AB/157/25/L

38 Maltravers Street Arundel BN18 9BU

Listed building consent for the replacement of 2 No existing external gates.

Drawing Name
Gate 2 Elevations -
Proposed

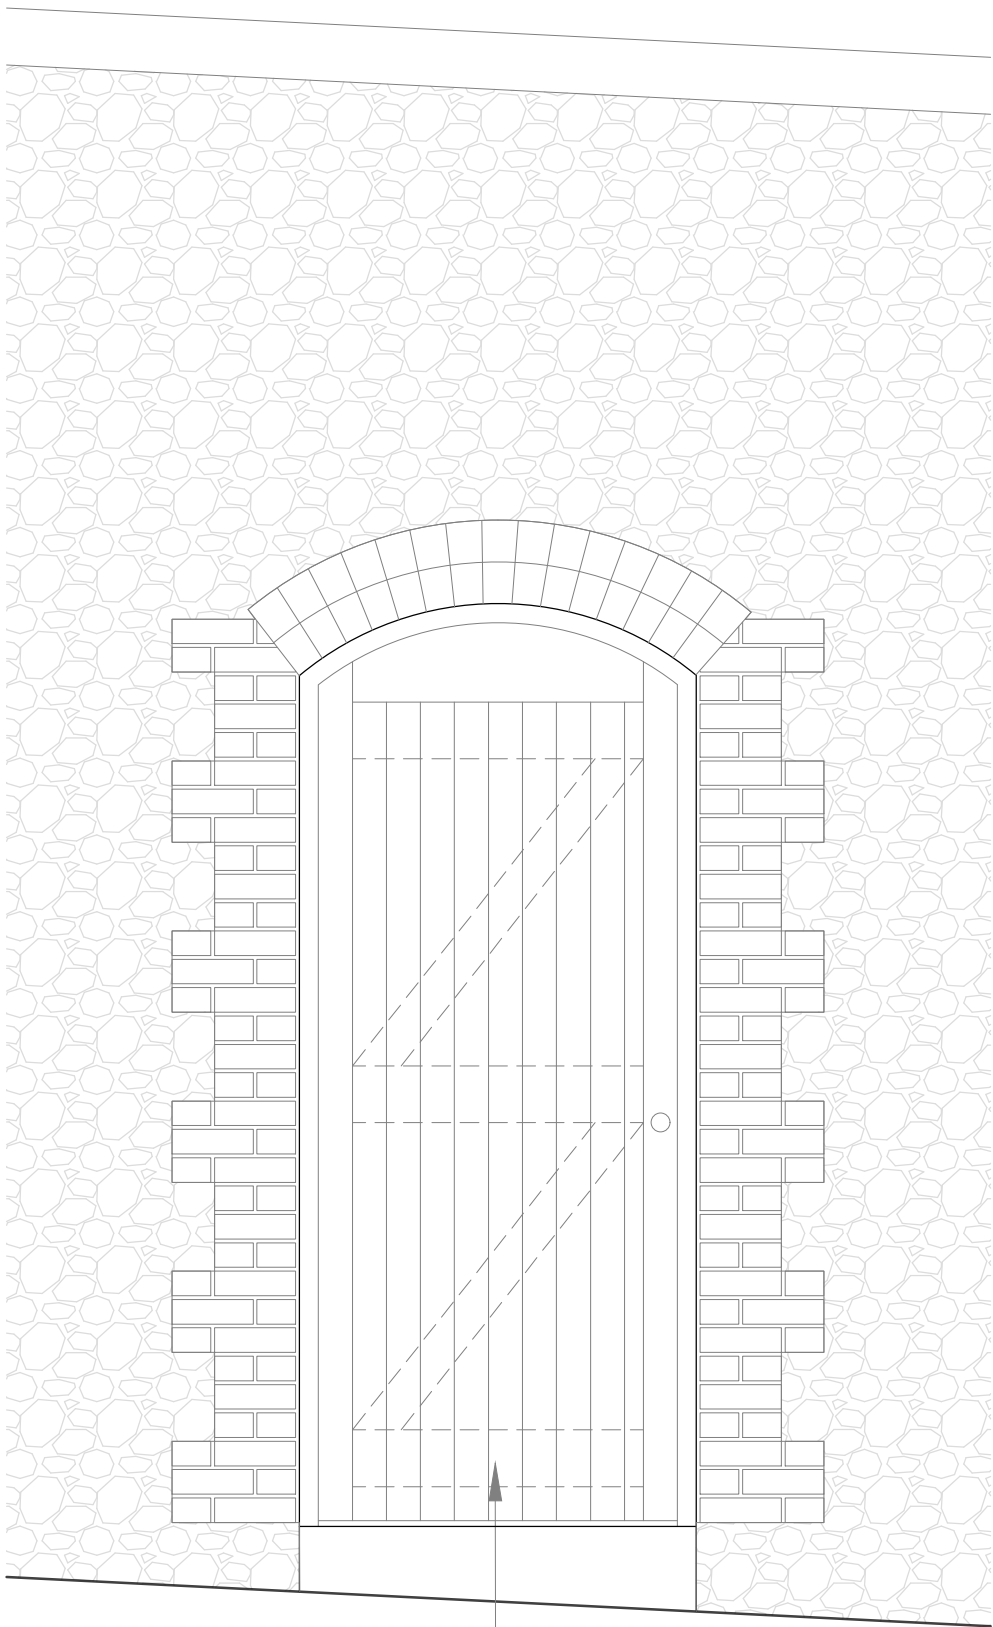
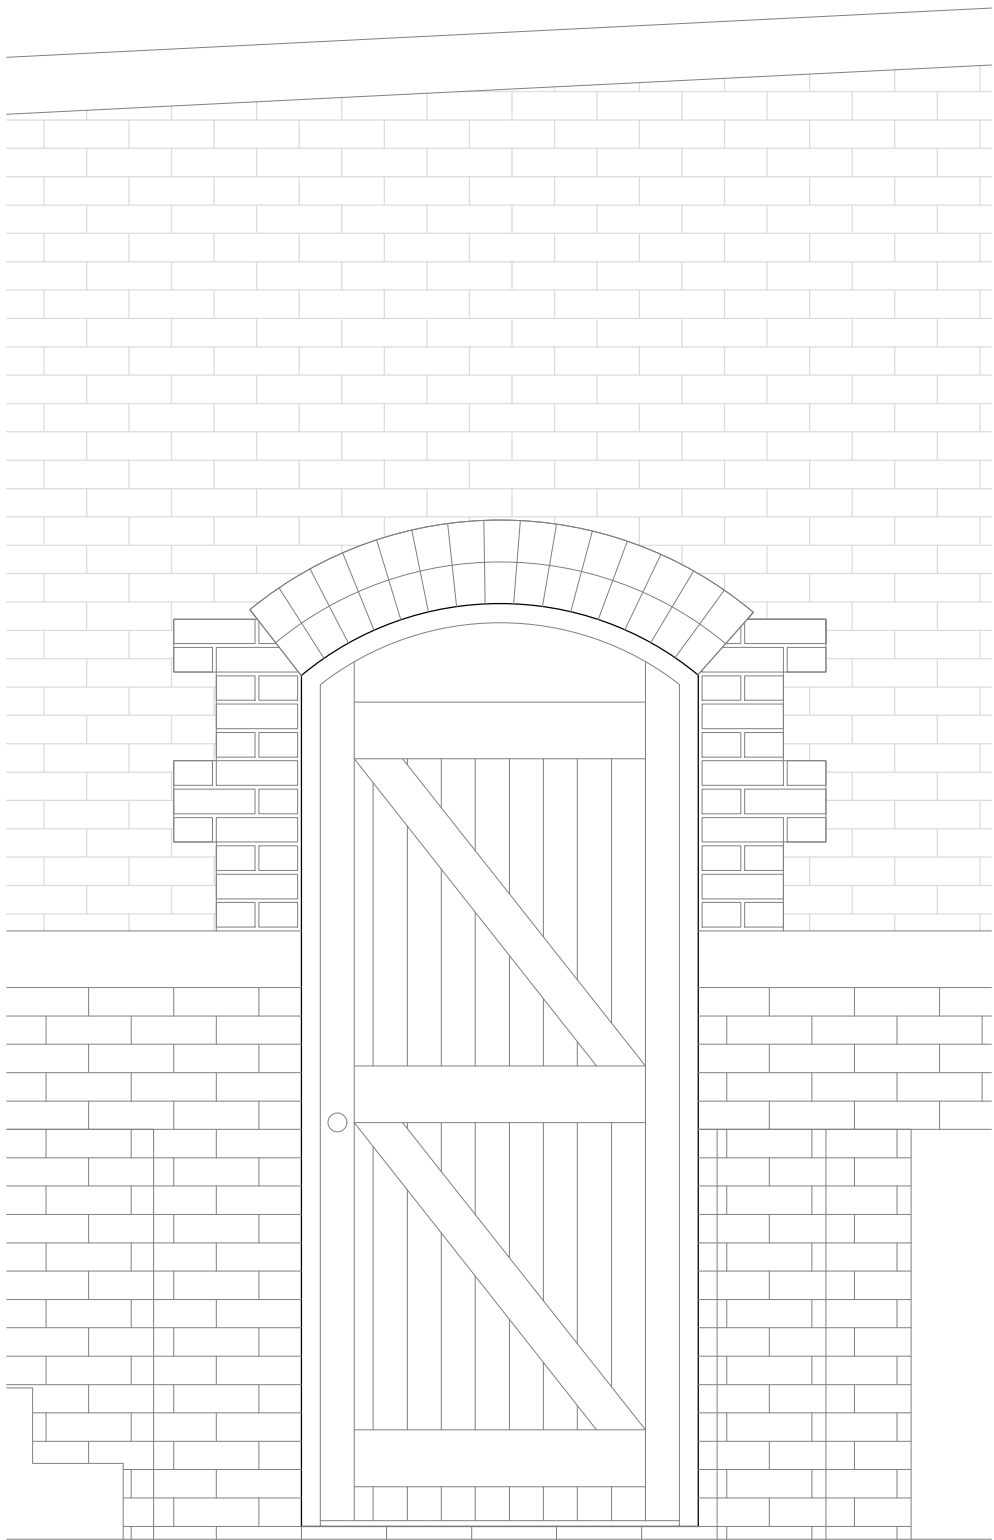
The proposal is for the replacement of two existing external gates. While the justification for their replacement is not fully explained, I am satisfied that the proposed designs would not cause harm. However, although it is stated that the gates will be constructed in air-dried oak, it is not specified whether they are to be painted, oiled, or left to weather naturally. Please can this be confirmed?
